REPORT UPDATE

Application No: A/8/18/PL

LOCATION: Land Rear of 1 To 6
The Cottrells
Angmering
BN16 4AF

PROPOSAL: Variation of condition 2 imposed under A/173/16/PL to read 'the development to be carried out in accordance with the following approved plans ADC 962/04 REVA, ADC962/13 & ADC962/14 relating to slight repositioning & change in size of building, revised position of rooflights on east, north & south elevations. This application affects the character & appearance of the Angmering Conservation Area.

Drawing Title				Drawing No		Rev
First Floor Plan & Roof Plan				ADC962/13		B
Date	Scale	Dwg Size	Plot Style	Drawn	Checked	
16.01.18	1:100	A3	ADGreyscale	AD	AD

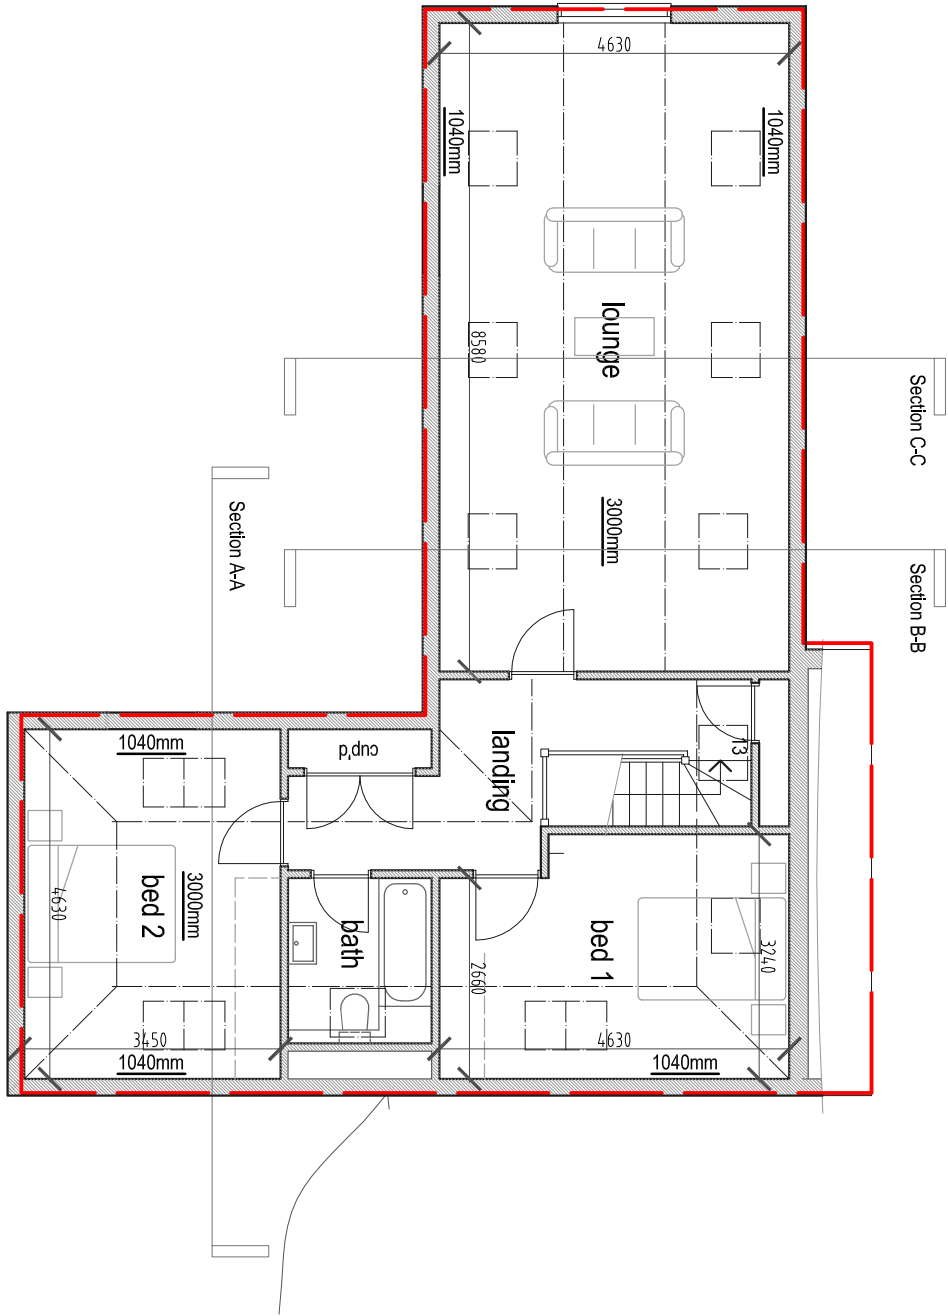
For further clarification the agent has submitted a revised first floor and roof plans ADC 962/13B with the outline of the approved scheme dotted in red. He also submitted a further cross section plan indicating the dimensioned internal floor height of windows on both side elevations is 1.5m..
